From: Maria Tomalova
Sent: 16 August 2019 10:15
To: Planning Scanning
Subject: FW: BR/154/19/PL, 8 Mead Court

From: Alastair Smyth [REDACTED]
Sent: 16 August 2019 08:18
To: Chris Moore [REDACTED]
Cc: Maria Tomalova [REDACTED]
Subject: Re: BR/154/19/PL, 8 Mead Court

SITE PLAN - 1/500

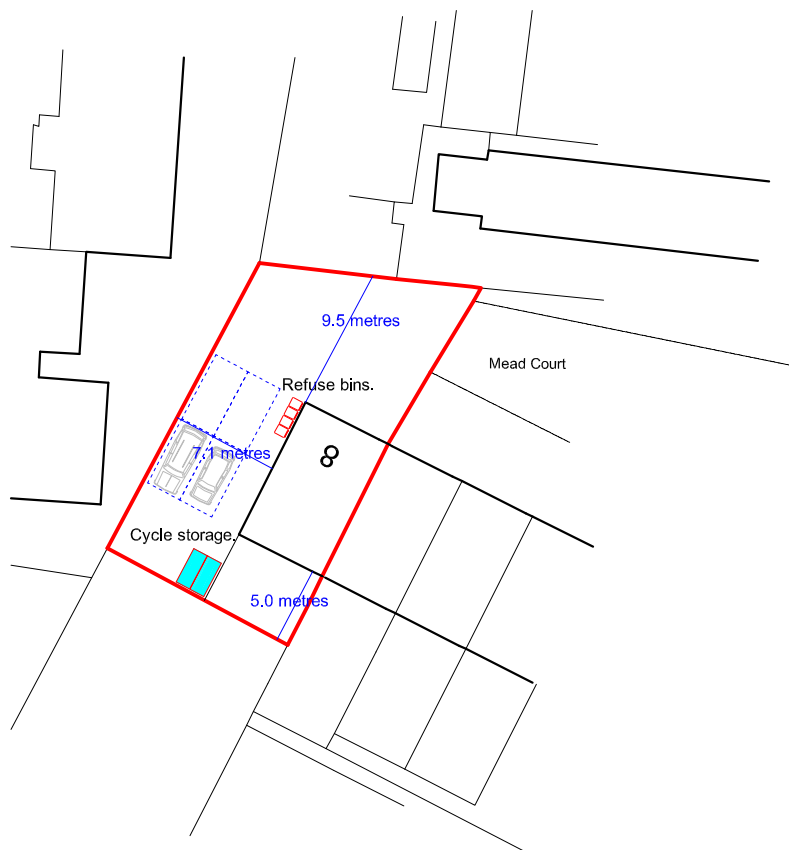
One of the grounds was a lack of parking spaces provided.
I have been on the site and the site is big enough to accommodate 4 cars,
What is a requirement for 8- bed HMO.

It would be helpful if you can demonstrate the provision of 4 parking spaces.

The site as you will know is more than capable of taking twice the amount, however, I attach a copy of a revised site plan indicating 4 x spaces as requested – I trust that this is ok?
